**WEST SUSSEX COUNTY COUNCIL
STRATEGIC PLANNING CONSULTATION**

SUBJECT: A/142/14/PL- Redevelopment of site for small Class B1 (Business, Light industry) and B8 (Storage or distribution) industrial units. Departure from the Development Plan.

Old Barn Nursery, Dappers Lane, Angmering, West Sussex, BN16 4EN

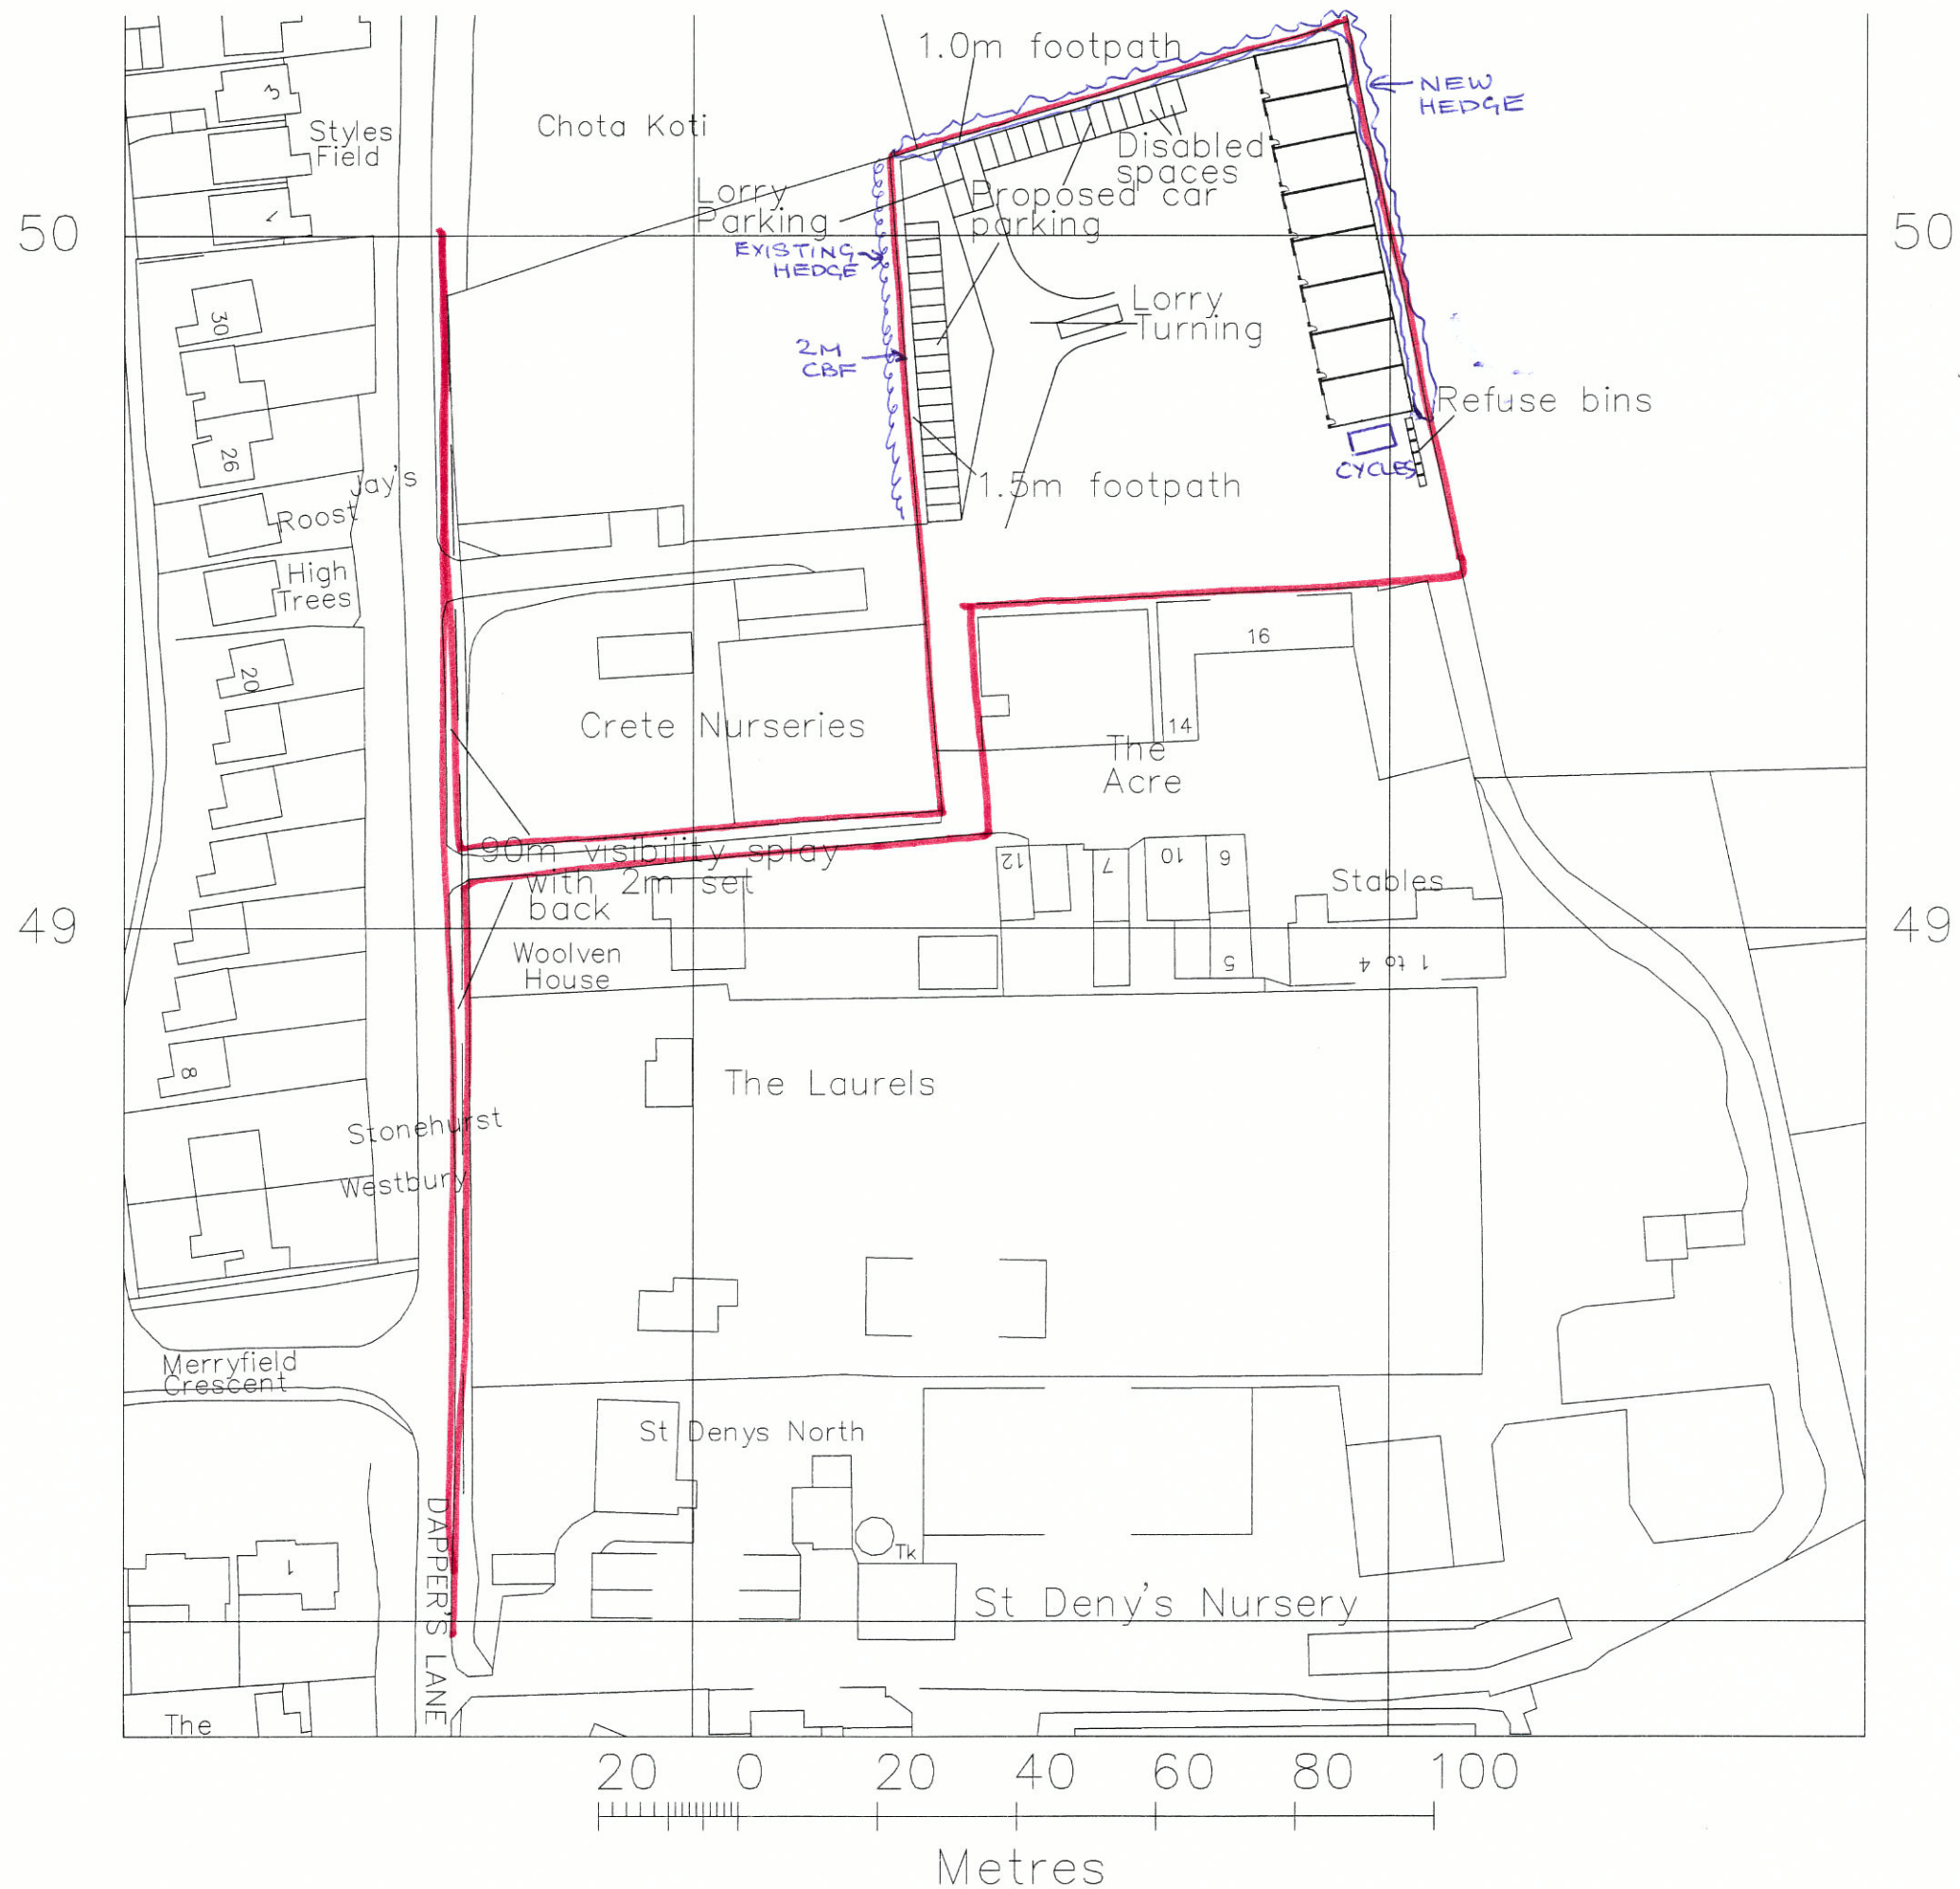
30 car parking spaces are proposed. The car parking provision has been considered against the WSCC maximum parking standards. The proposed parking provision is within the maximum standards.

Vehicular access to the site is possible only from Dappers Lane. No changes are proposed to the existing access arrangements. The site has an access road which is not part of the adopted highway and has an initial width of approximately 5.5 metres, narrowing down to

4.8 metres. From the red edge shown on the site plan it would appear that the applicant has control of a proportion the land to the south of the site, I would therefore advise that a large proportion of the existing hedgerow is cut back and maintained to achieve an adequate visibility splay.

No part of the development shall be first occupied until the car parking has been constructed in accordance with the approved site plan. These spaces shall thereafter be retained at all times for their designated purpose.

Within six months of the date of this planning consent, maximum visibility splays shall be provided at the site access onto Dappers Lane in accordance with a plan to be submitted to and approved by the planning authority. These splays shall thereafter be kept clear of all obstructions to visibility above a height of one metre above the adjoining road level.
